SHARON LAKES PLAZA
ALTERNATE
SITE PLAN
FOR NEW FENCE SCREENING

DATE: September 16, 1992
TO: Robert Brandon, Zoning Administrator
FROM: Martin R. Cramton, Jr., Planning Director
SUBJECT: Revised Alternate Buffer Plan for Sharon Lakes Plaza, 7701 Sharon Lakes Road, Tax Parcel #173-242-01

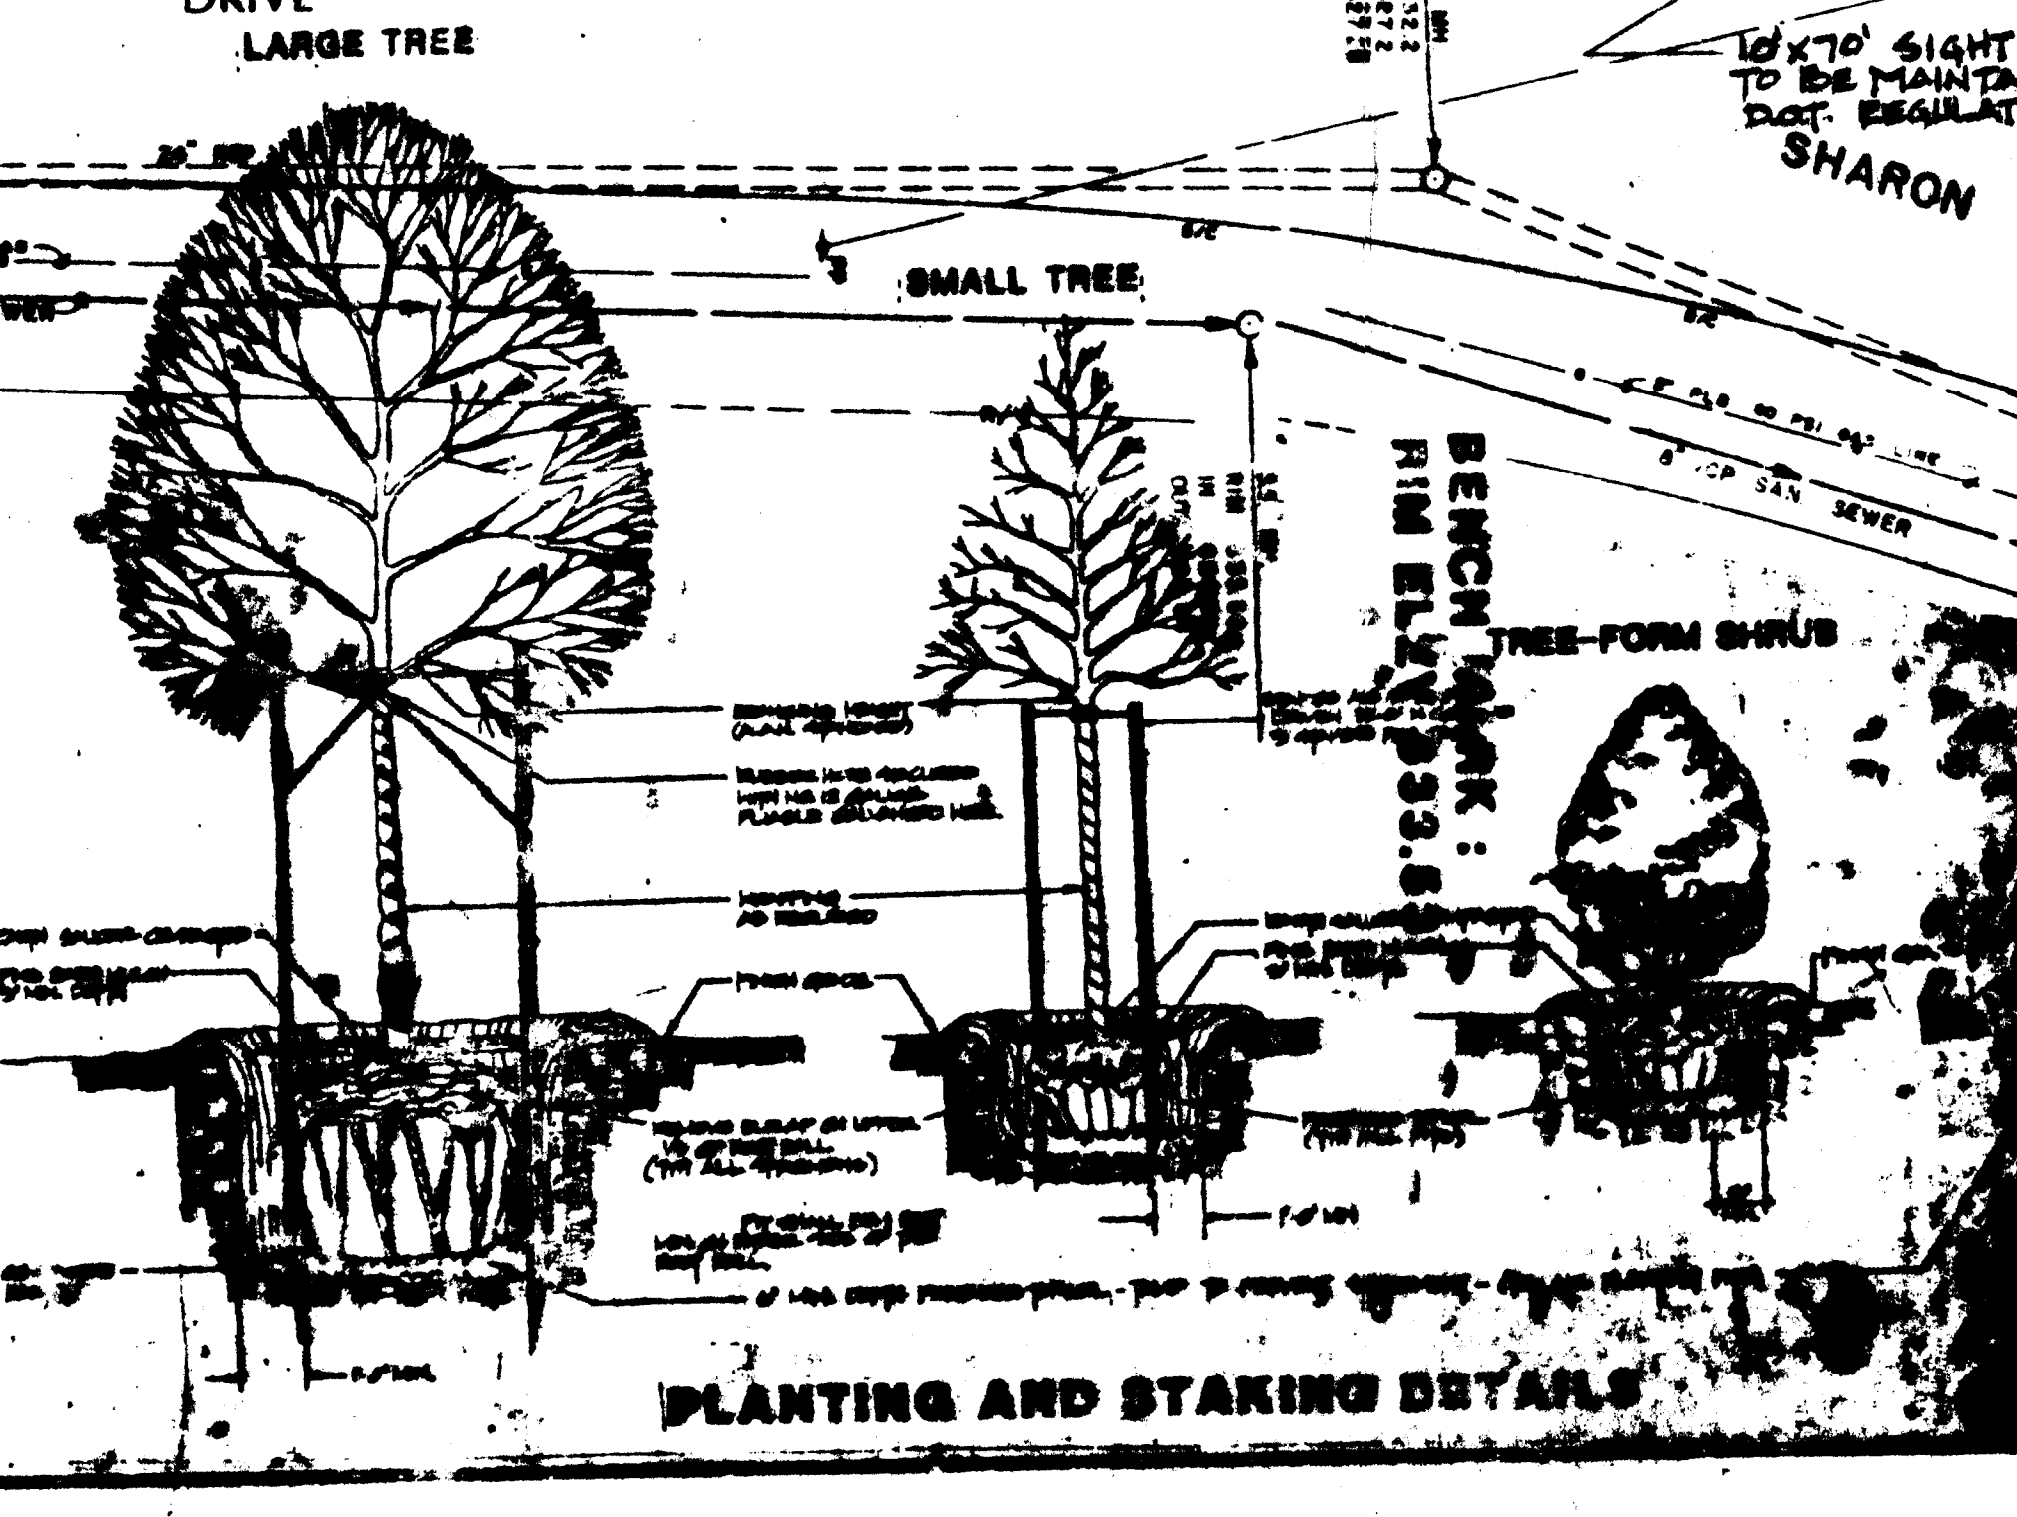
Attached is a revised landscape plan for the above mentioned project. The plan has been revised to substitute a 6.0 foot wooden fence for the proposed Layland Cypress. Please use this plan when evaluating requests for building permits and certificates of occupancy.
